Date 12 February 2024
Our Ref 24/00096/FUL

Town and Country Planning Act 1990 (As Amended)
48 Rosebank, Epsom, Surrey
Formation of new dropped kerb with vehicular access incorporating new hardstanding driveway.

Drawing No. SC / 23 / 134 - 101	Rev	
Scale 1:100 @ A3	Date -Oct 2023	Planning
Created By A Mc	Check By	Bulking Control
		Client
		Sketch
		Information

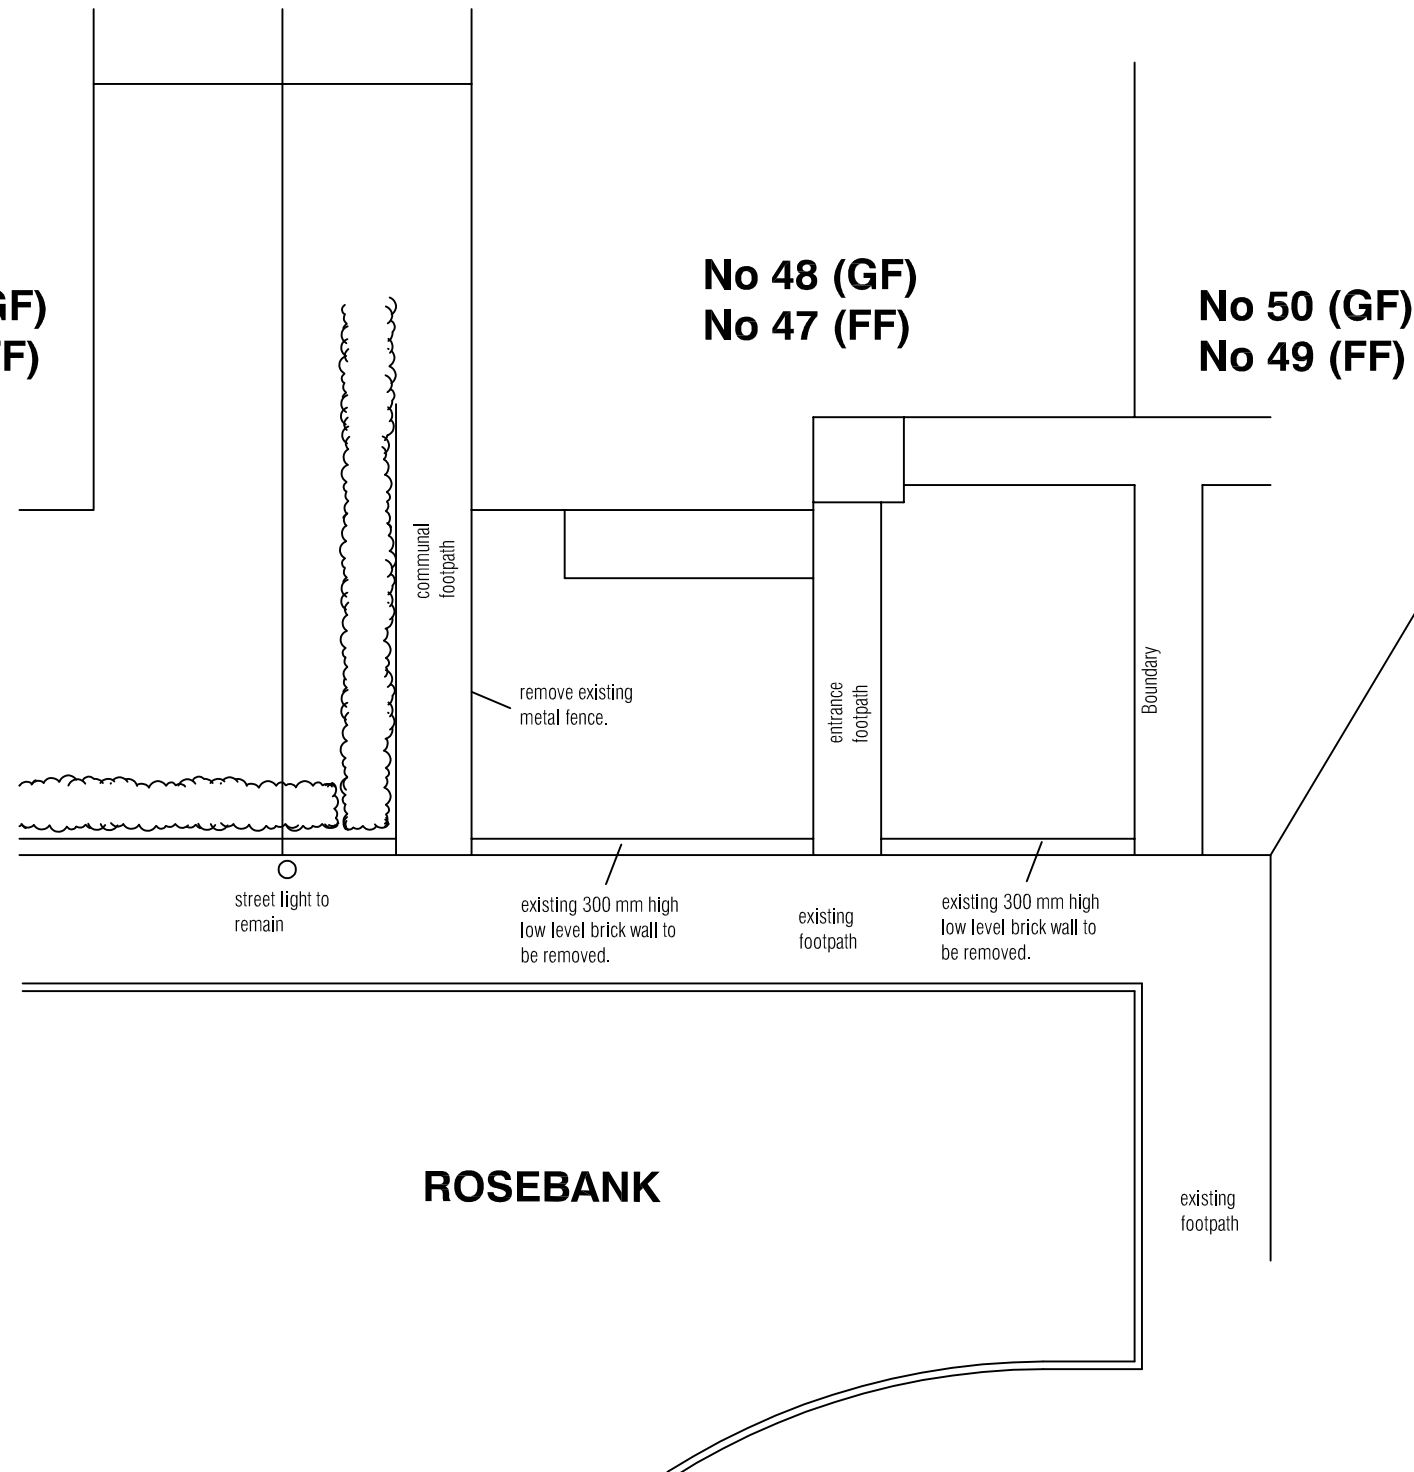
2 LOCATION PLAN AND EXISTING AND PROPOSED SITE/BLOCK PLAN - We acknowledge receipt of the submitted plan. However, these do not meet our requirements. For guidance, we have attached a sample Location Plan, Existing Site Plan and a Proposed Site Plan detailing how the red line needs to be extended up to the highway and to include the pavement. Please note how the Existing and Proposed Site Plans show the current situation and the proposed situation (hatched). The Location plan is to be at scale 1:1250 and the Site Plans at 1:200 or 1:500.
